## CITY OF PORTLAND

July 28, 1999

RE: 36 Newton St  
CBL: 337-C-054

It was recently noted that your swimming pool was not installed in accordance with Section 421.0 of the 1996 BOCA Code as stipulated in your permit issued May 26, 1999.

DECK TO POOL

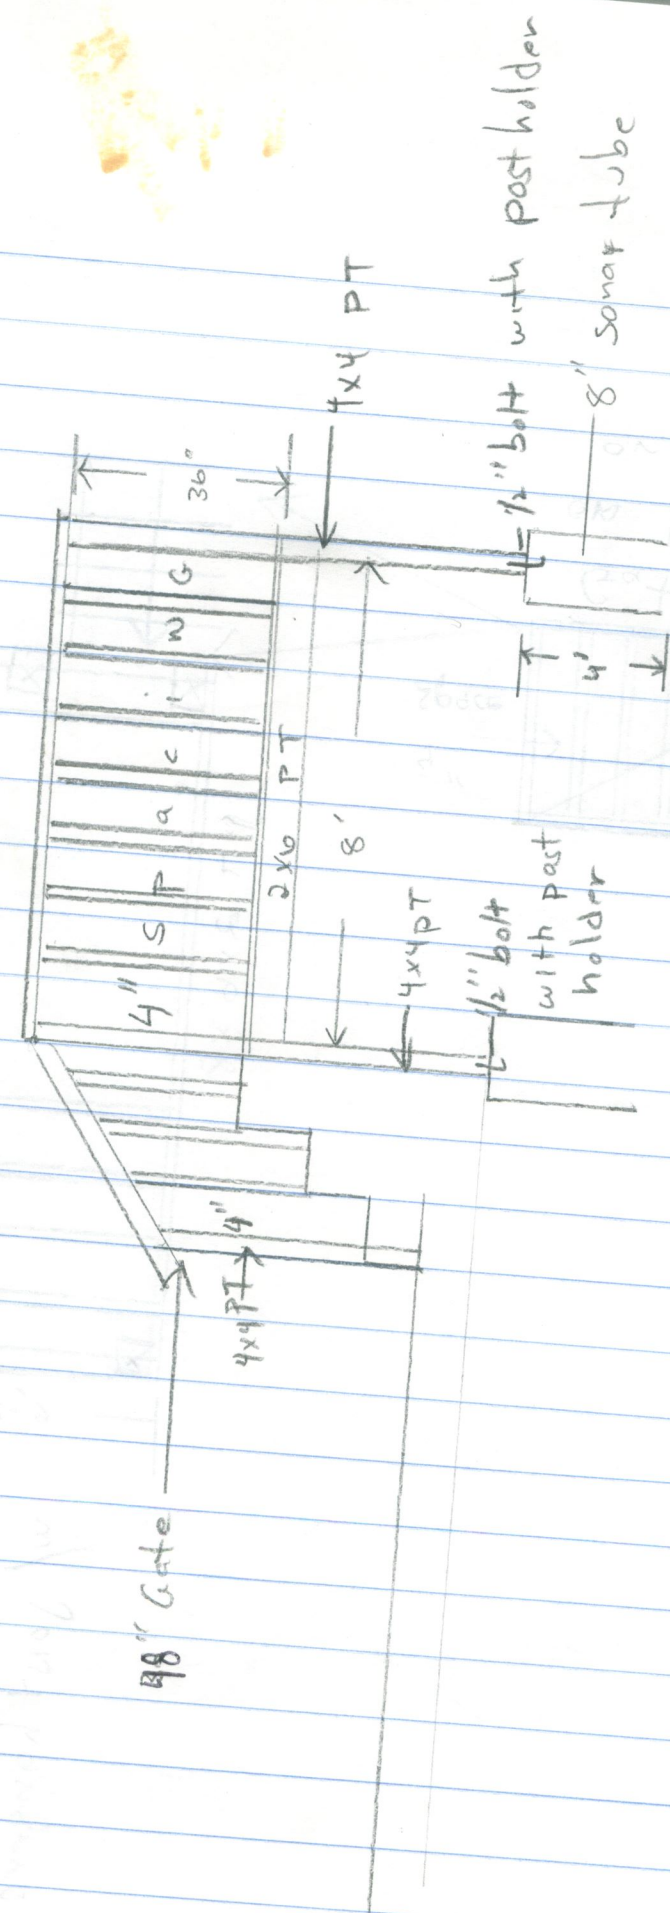
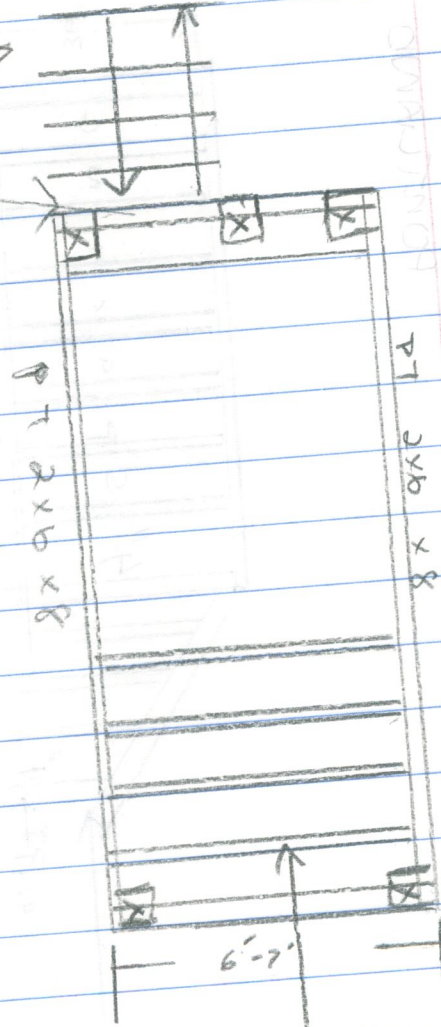
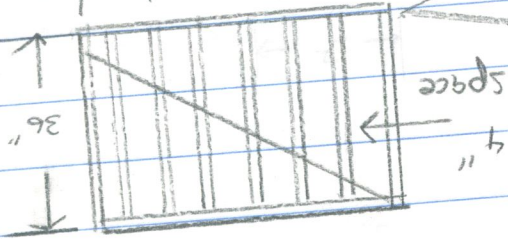
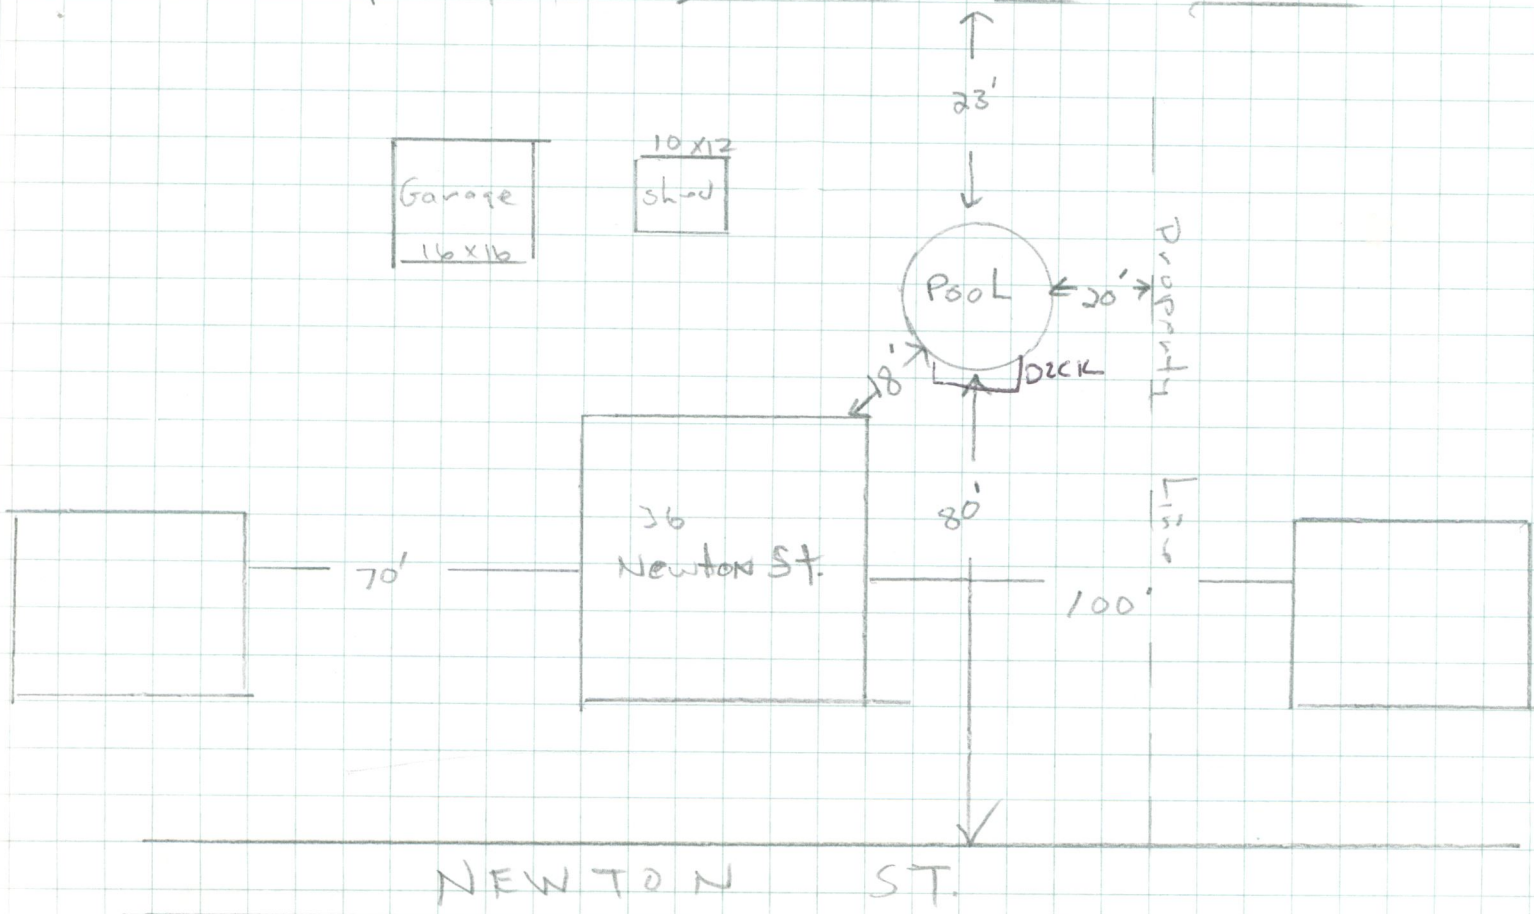
The deck around your pool was not built according to plan. The balusters were horizontal so as to create a ladder affect. The gate did not meet height requirements.
